Harnett County Government Complex  
307 Cornelius Harnett Boulevard  
Lillington, NC 27546

June 27, 2005

Re: Status of Improvement Permit Application #05-5-12383  
Second Letter Lt. 20

LOT #20
0.73± ACRES

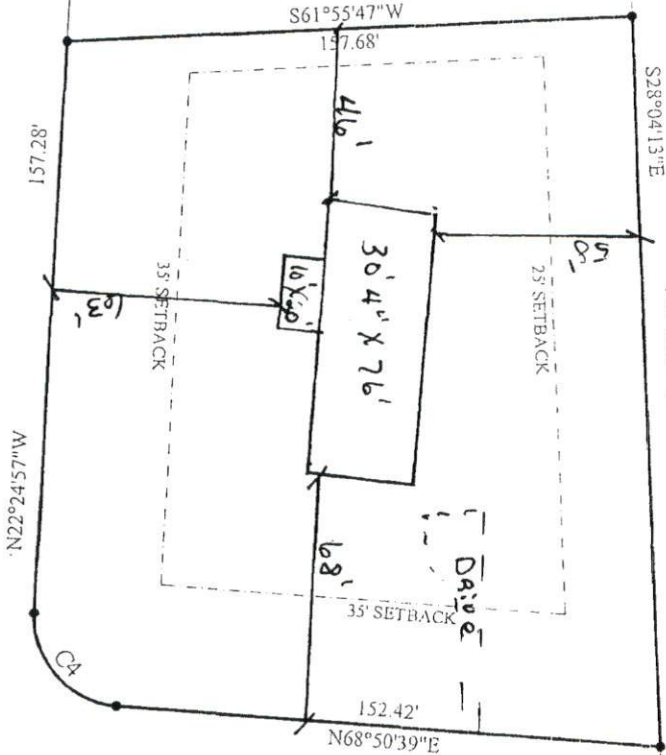
- 1. Property lines/corners not marked or labeled
- 2. House corners not marked or labeled
- 3. Directions not clear to property
- 4. Property needs brush or vegetation removed
- 5. Backhoe pits required
- 6. Other **Must move home as shown on following page. Must reduce home from 4 bedroom to 3 bedroom and submit changes to Central Permitting.**
